Our Ref: 2397/RLP/01

APPLICATION NO 2023/92066 - ERECTION OF TWO SEMI DETACHED DWELLINGS WITH ASSOCIATED ALTERATIONS AT 89 WHITCLIFFE ROAD, CLECKHEATON

Mark	Oct 23	Date	Made by	Revision
Drawing Title:				
Proposed Floor plans Elevations				
Site Address:				
89 Whitcliffe Road Cleckheaton BD19 3EA

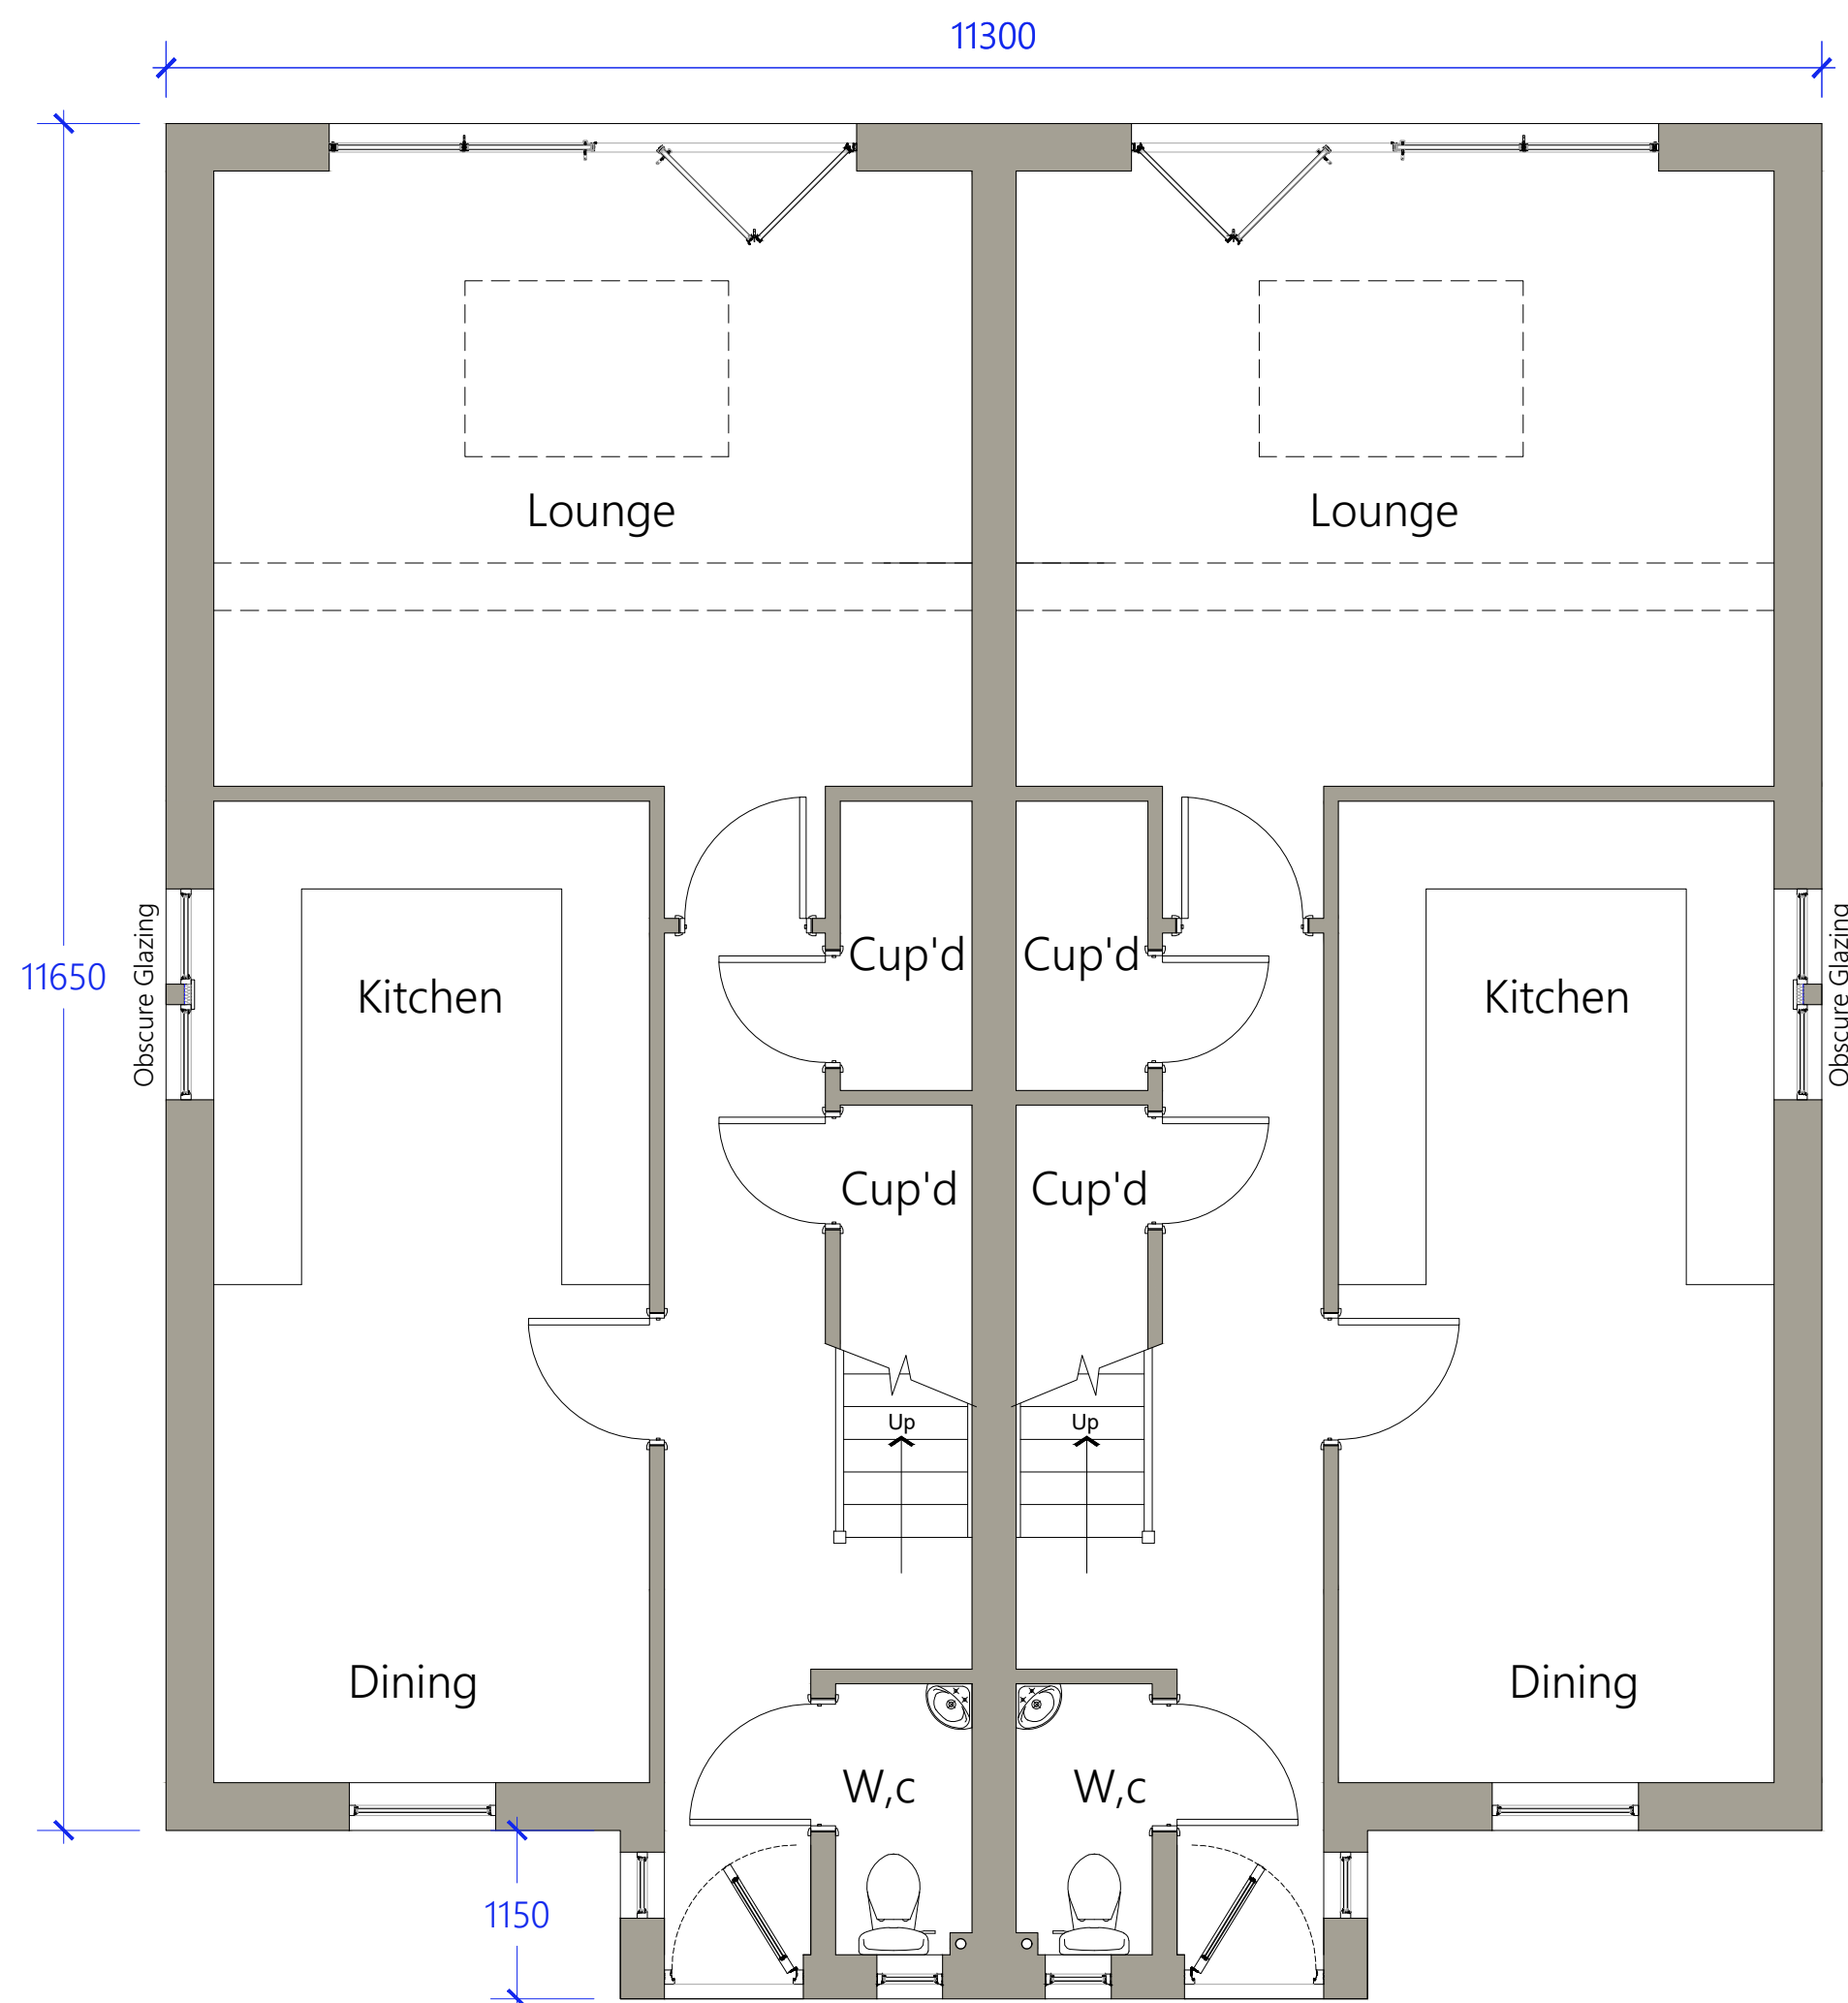
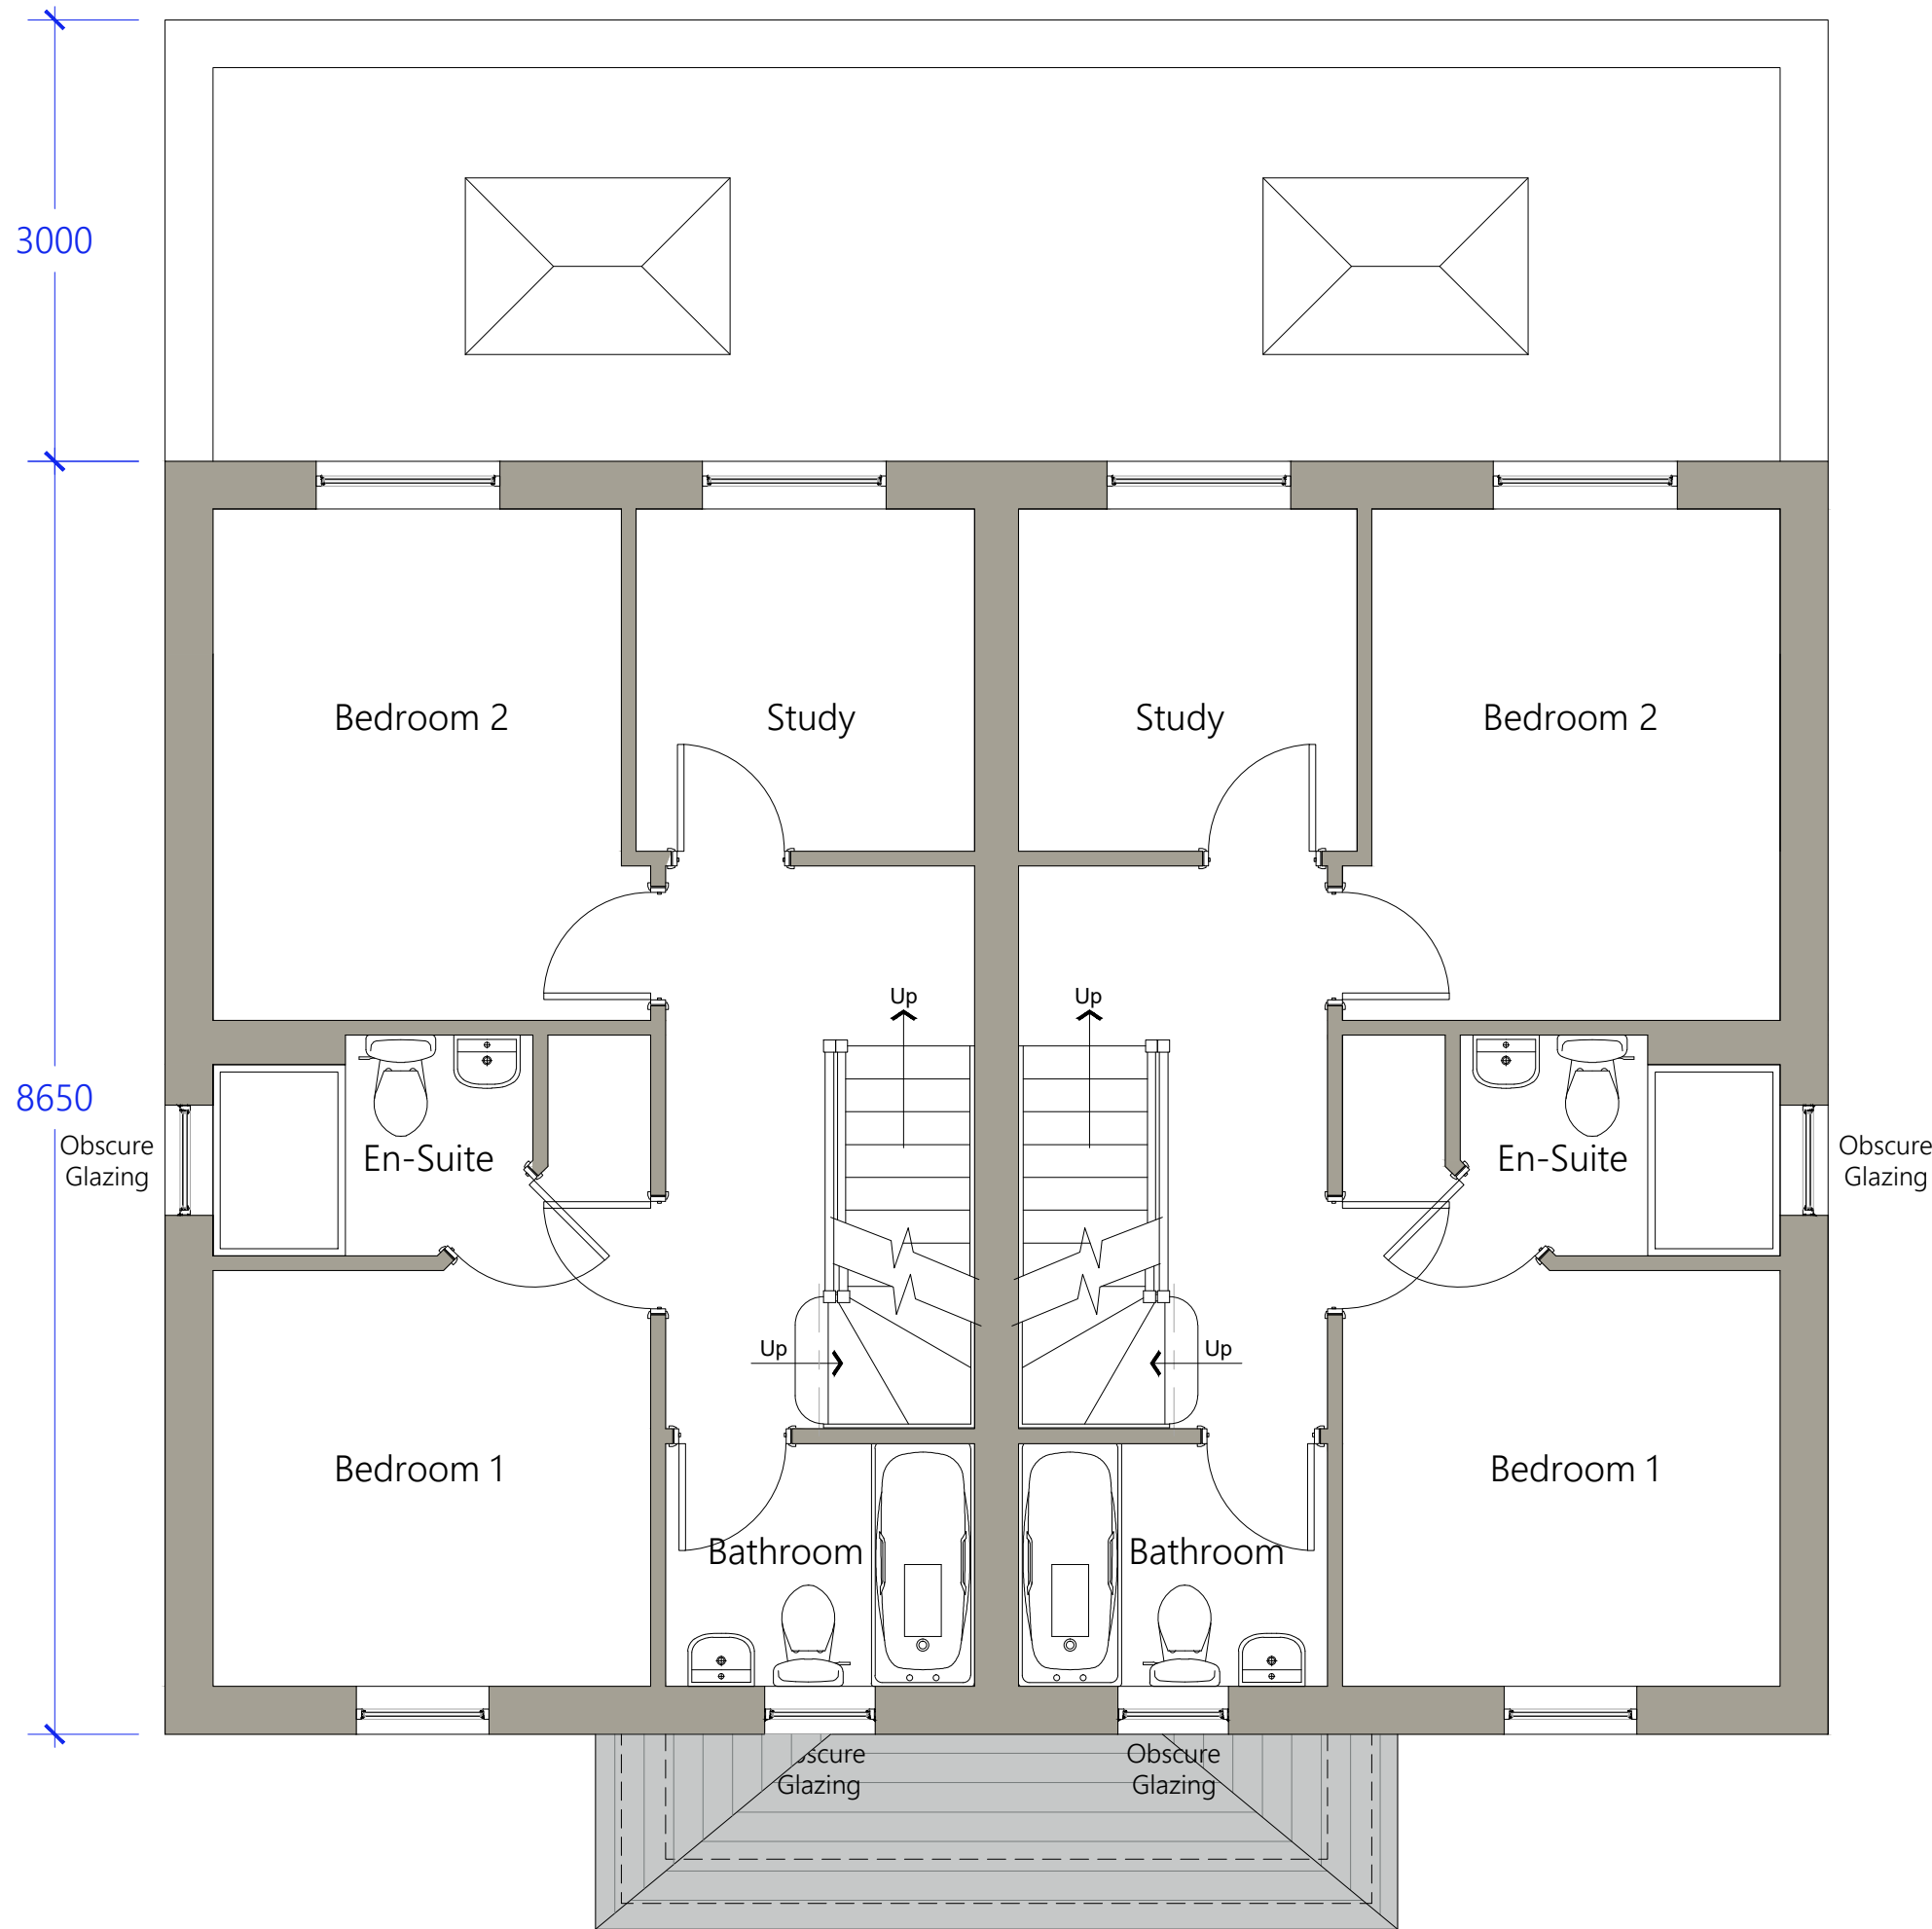
The proposed plans show a pair of 3 bed semi-detached houses, potentially 4 beds given that a study is indicated for each plot.

It is noted also that kitchen windows are shown in the side elevation of the plot facing towards Grove House. Whilst the drawings indicate that these will be obscure glazed this is not an ideal solution to overcome what is a shortfall in minimum distance standards. Such windows could easily be changed to clear glass in the future and a better solution would be to have the windows at a high level to prevent any potential conflict.
